Office of
Environment
& Heritage

Re: Exhibition of Coraki Quarry (SSD 7036)

Attachment 1: Detailed OEH Comments – Coraki Quarry (SSD 7036)

Figure: 1.1
Title: Site Map

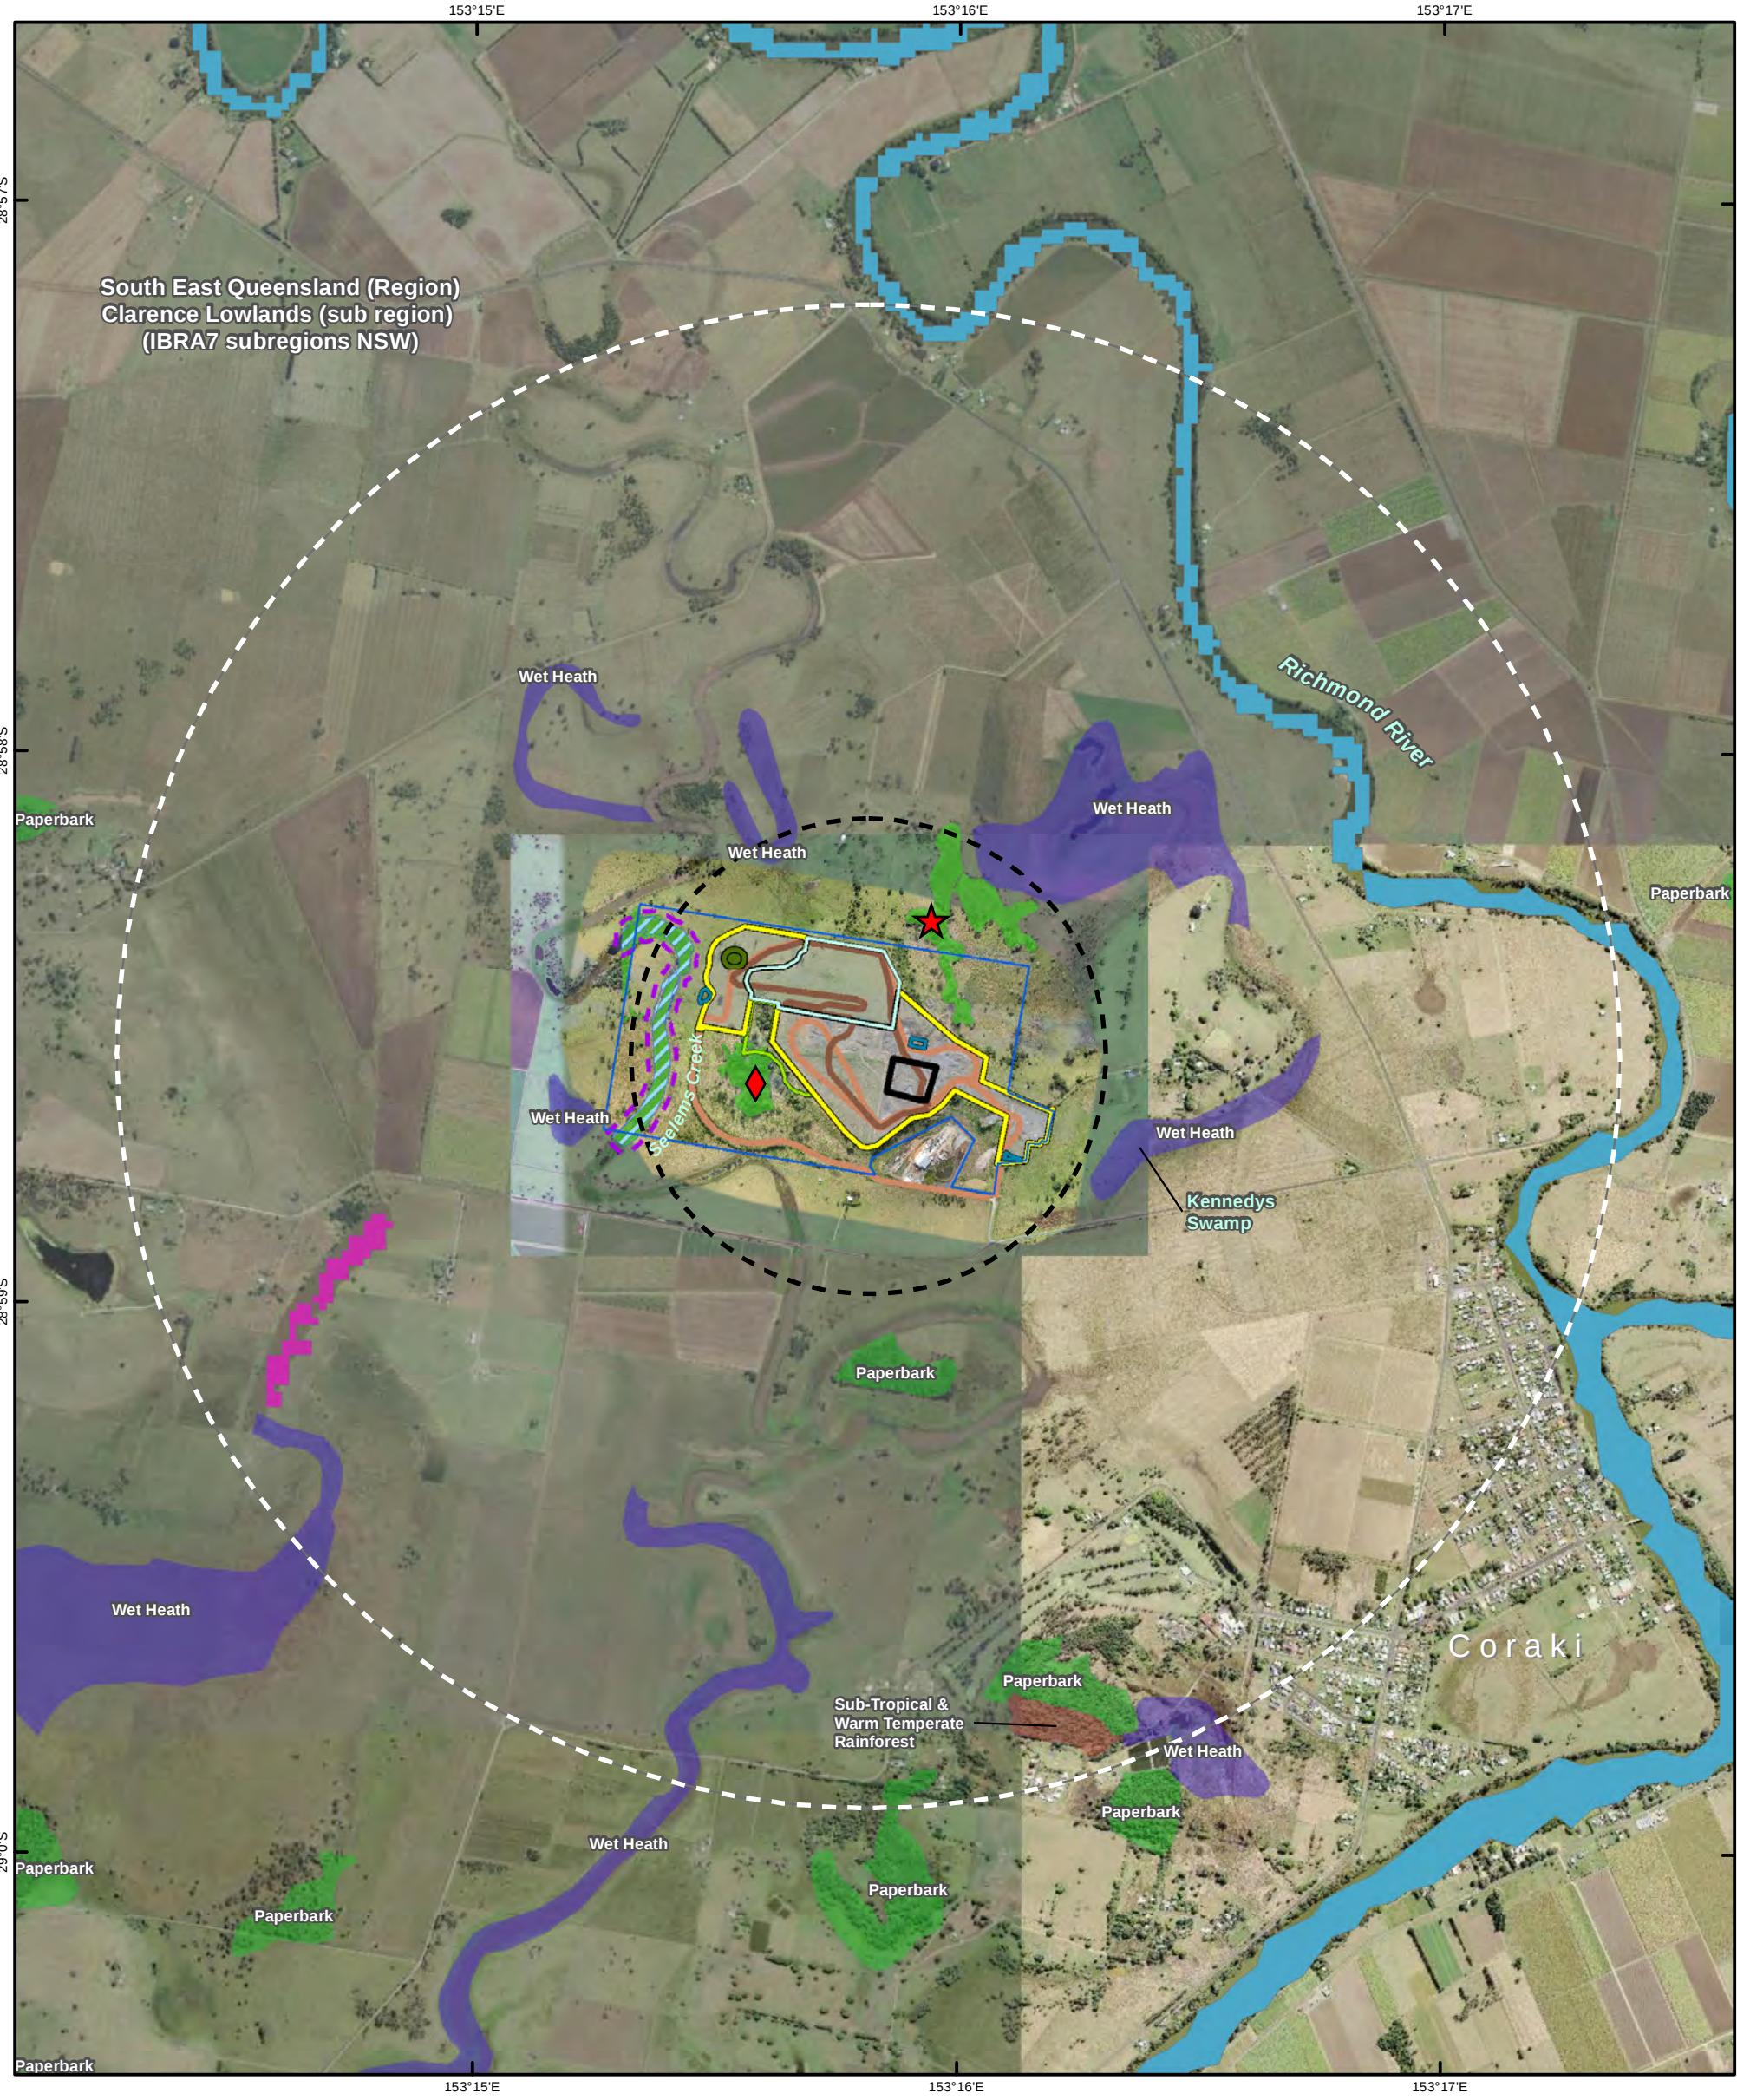
- We note the presence of four *Macadamia tetraphylla* on the site which are listed as threatened species under both state and commonwealth legislation. It is proposed to protect these plants on site and provide a 25m buffer. These plants and the buffer are located with the proposed stockpile area. It is unclear how this area will be managed sustainably into the future. The management of the plants and the buffer area should include the rehabilitation of other suitable rainforest plants and weed control to provide suitable habitat for flora and fauna and reduce indirect impacts.
